Re: Proposed 5-lot Subdivision, Engineer's Stamp Dated 5-24-07  
Lots 13 & 14 Block 6 of the Edward Krogh Addition, (H13/D52)

Re: Proposed 5-lot Subdivision, Engineer's Stamp Dated 3-14-07  
Lots 13 & 14 Block 6 of the Edward Krogh Addition, (H13/D52)

Based upon the information provided in your submittal received on March 19, 2007, there are some additional items that need to be addressed prior to the issuance of any Building Permits or approval for DRB action on the proposed Preliminary Platting Action. Those items are as follows.

LOTS 13&14, BLK 6, EDWARD KROGH ADDN
PROPOSED LOTS 1 THRU 5.
GRADING AND DRAINAGE PLAN

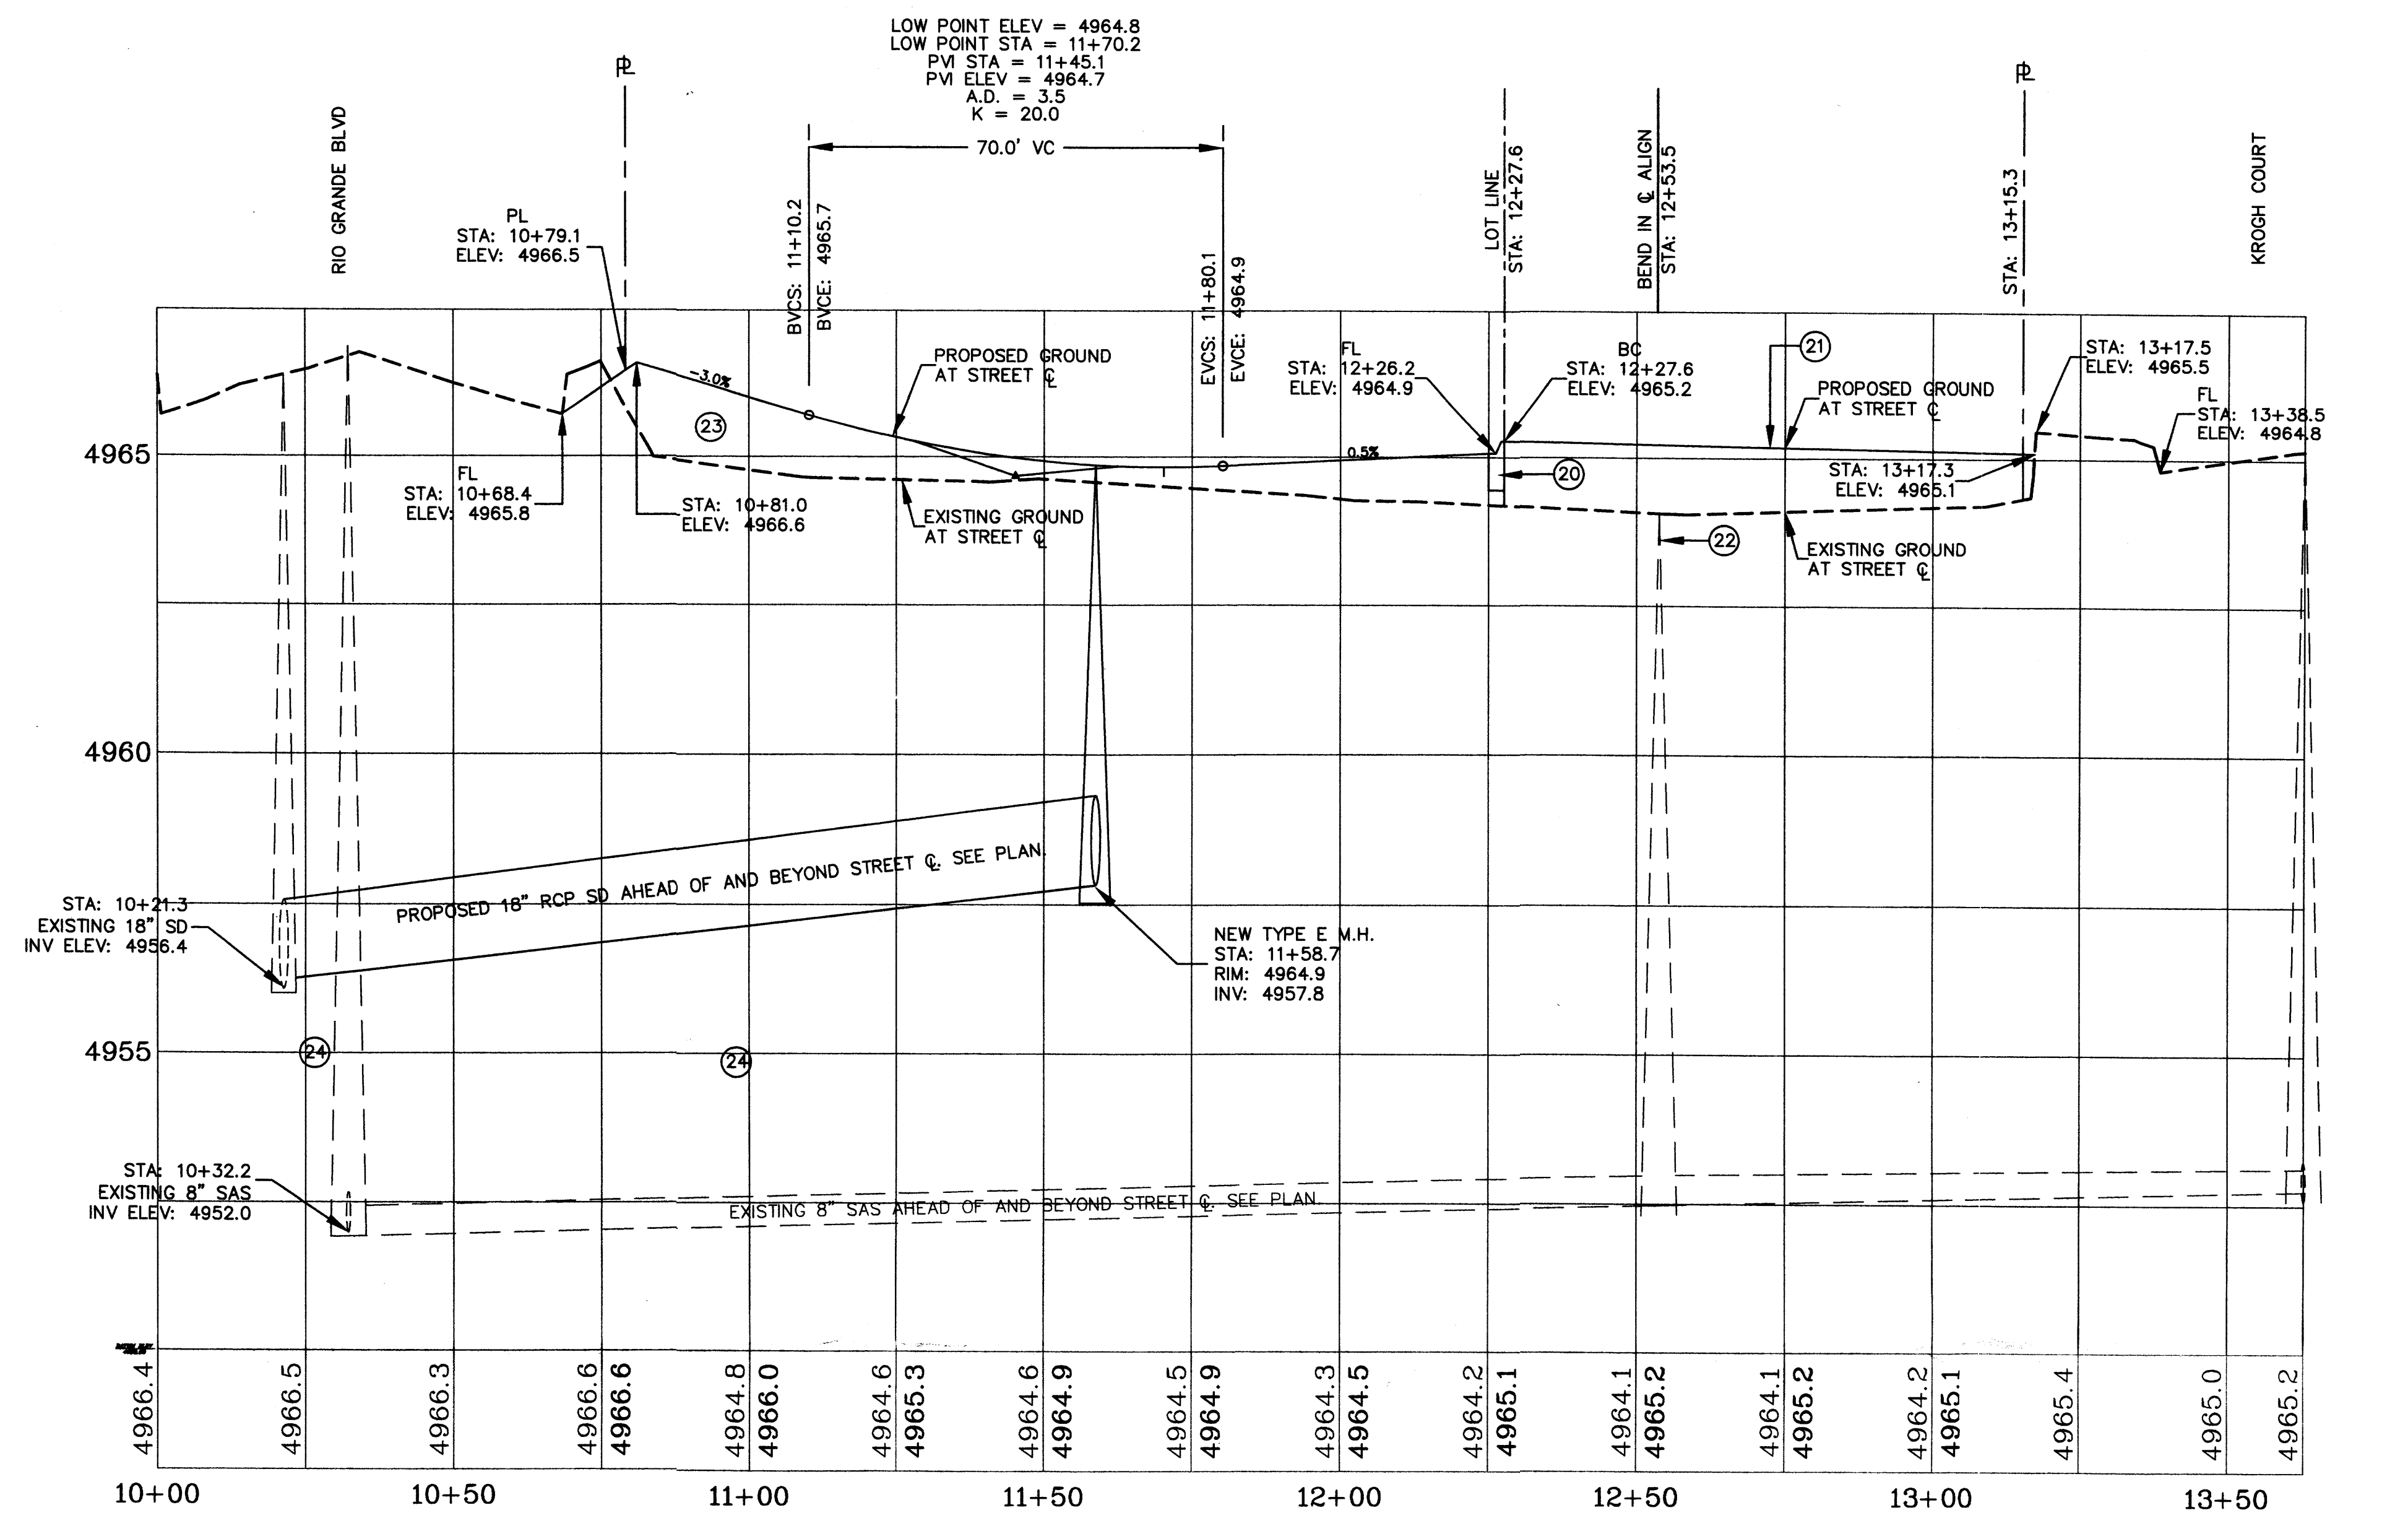
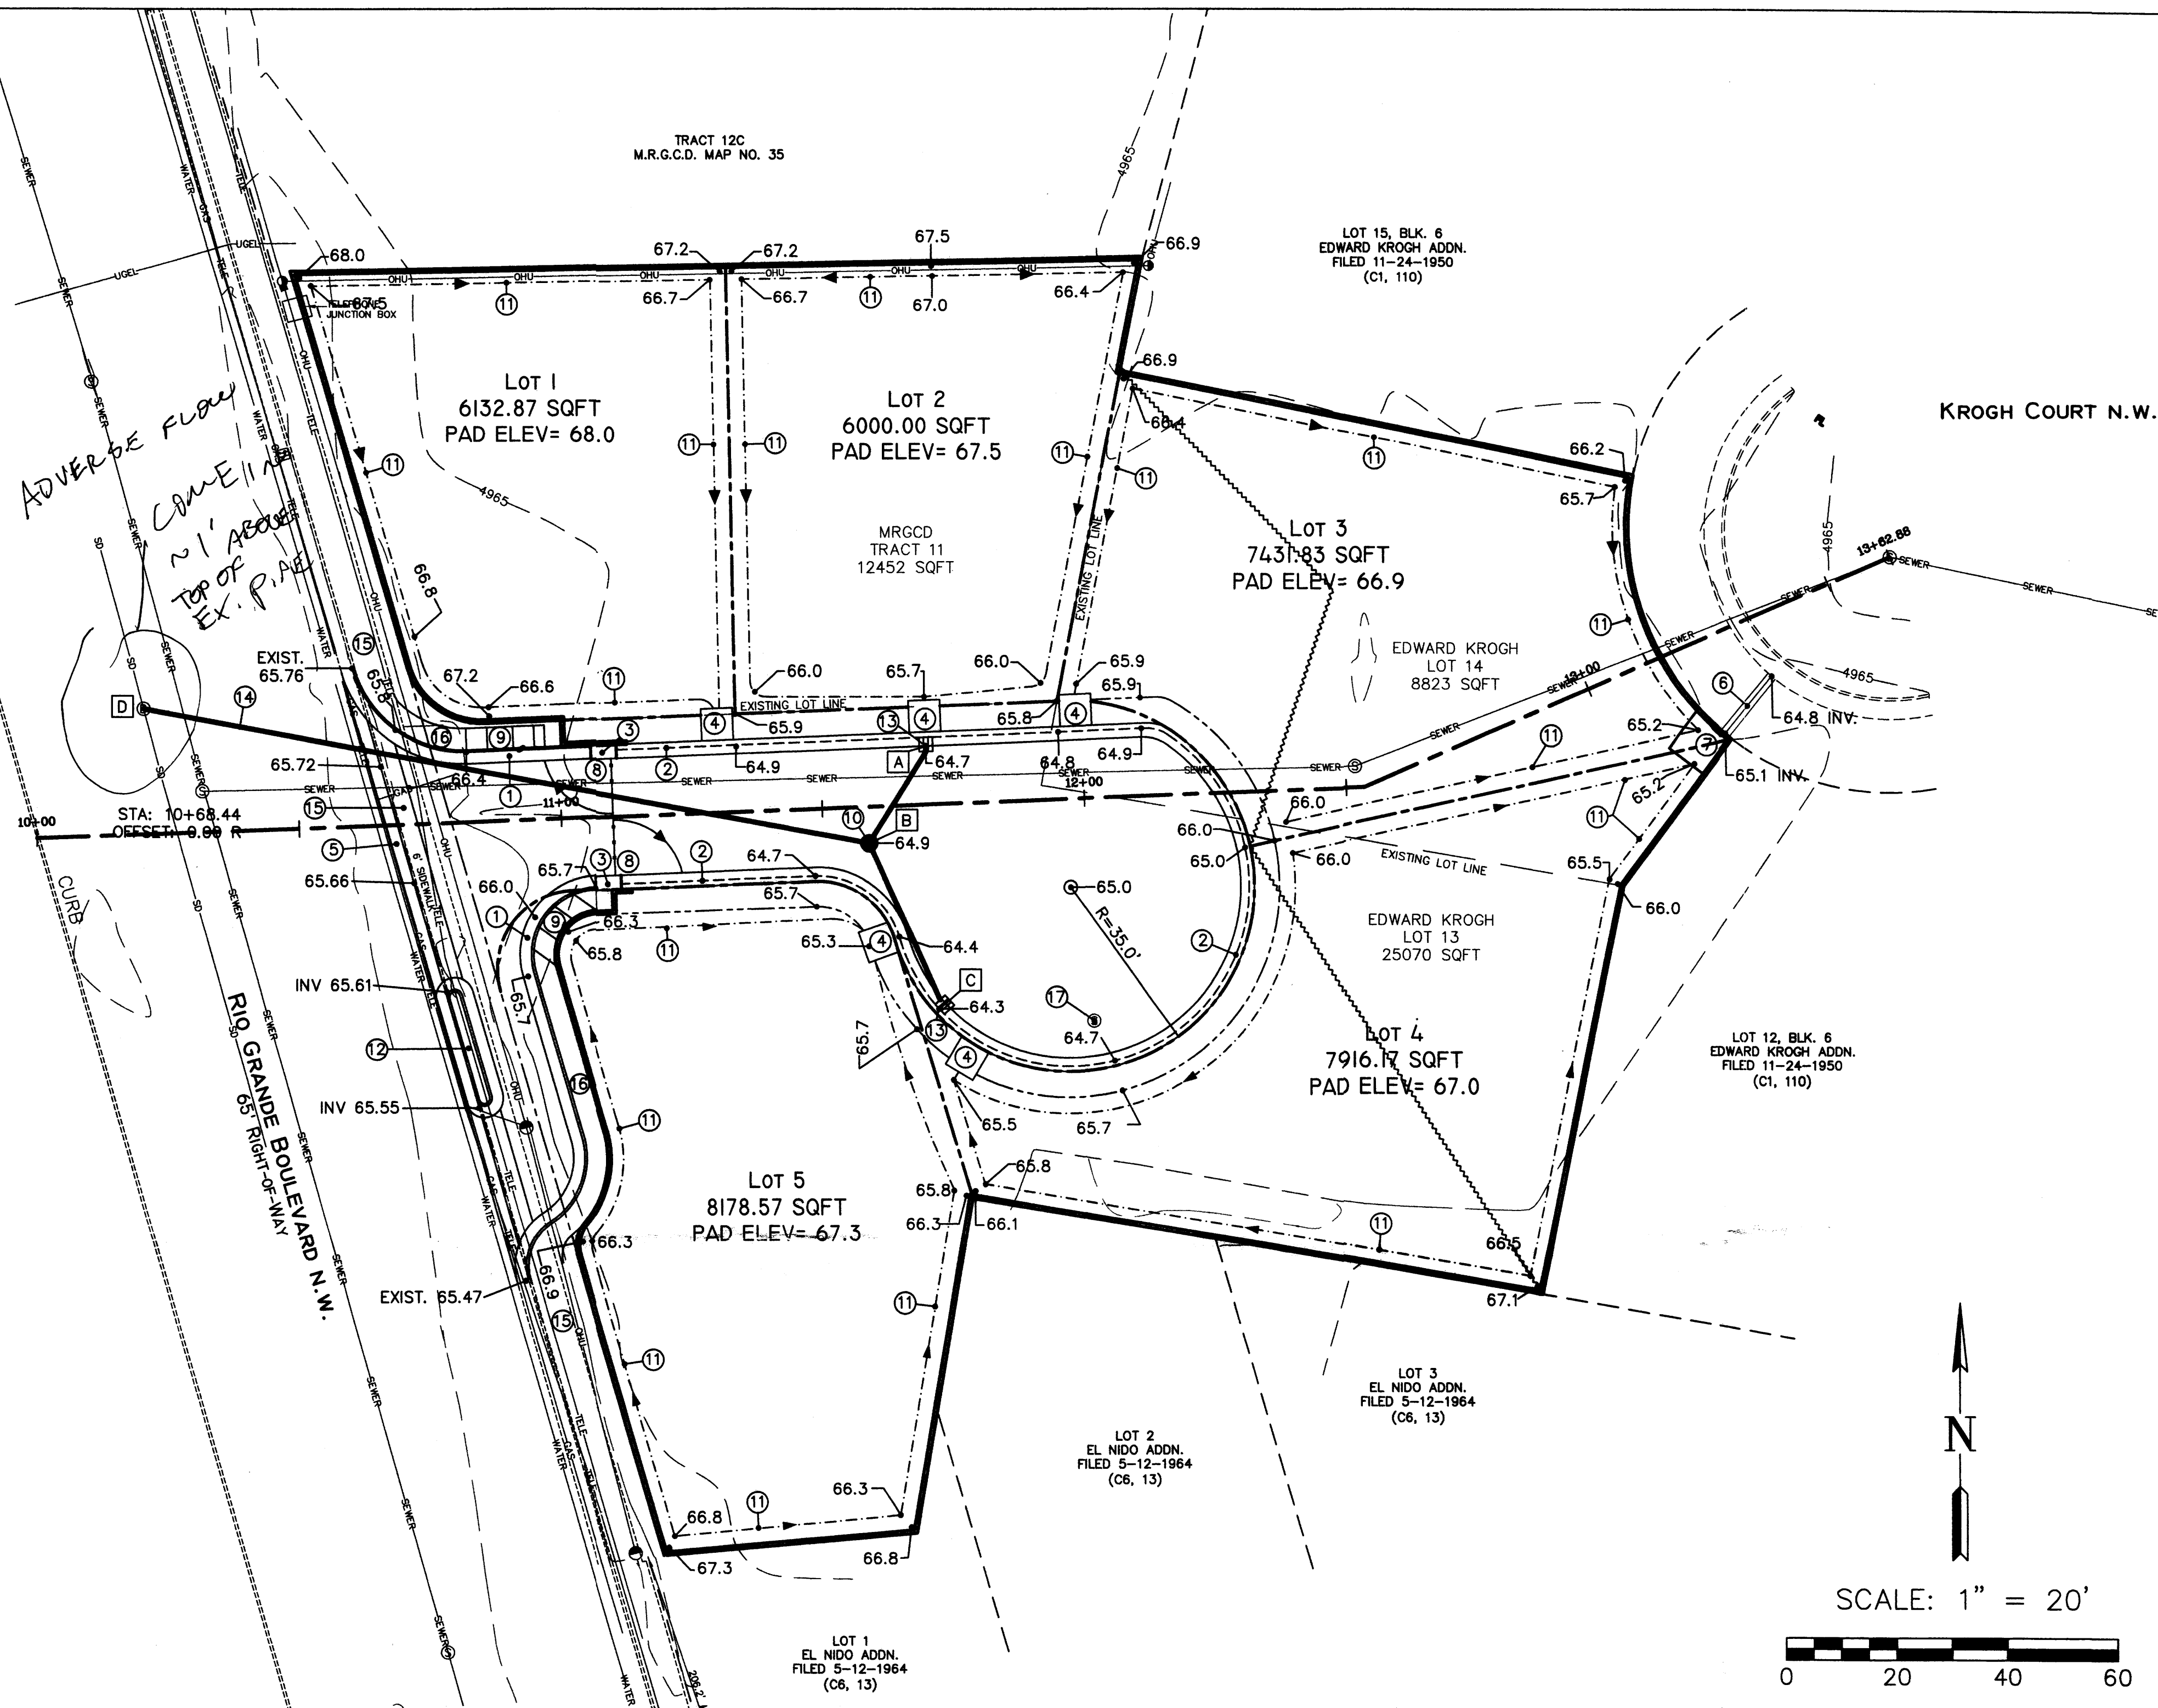
- Please provide a drainage narrative to describe the existing versus proposed flow patterns. Has any off-site flow historically entered the site?
- The lot line geometry suggests that the roadway and subsequently the infrastructure would be publicly owned. This conflicts with the concept of a gated subdivision. Please address this in the narrative as well.

- What is the total flow and volume generated by the site? How much will go to Rio Grande and how much will drain to Krogh Ct.?
- Please provide the exact acreage of the existing property. An NPDES permit may be necessary.

- On what permanent benchmark were the site elevations based?
- You show a manhole in the southern portion of the proposed cul-de-sac but it is unclear as to its purpose. Please define this element.

- Due to the designation of Rio Grande as an arterial roadway, a public Work Order will need to be initiated for the storm drain connection and construction of the sidewalk culvert.

- Will sidewalks be included with the site work? Please define the sidewalks in the legend and call out standard drawing #2430. What areas would be 6-foot sections and what would be 4-feet?
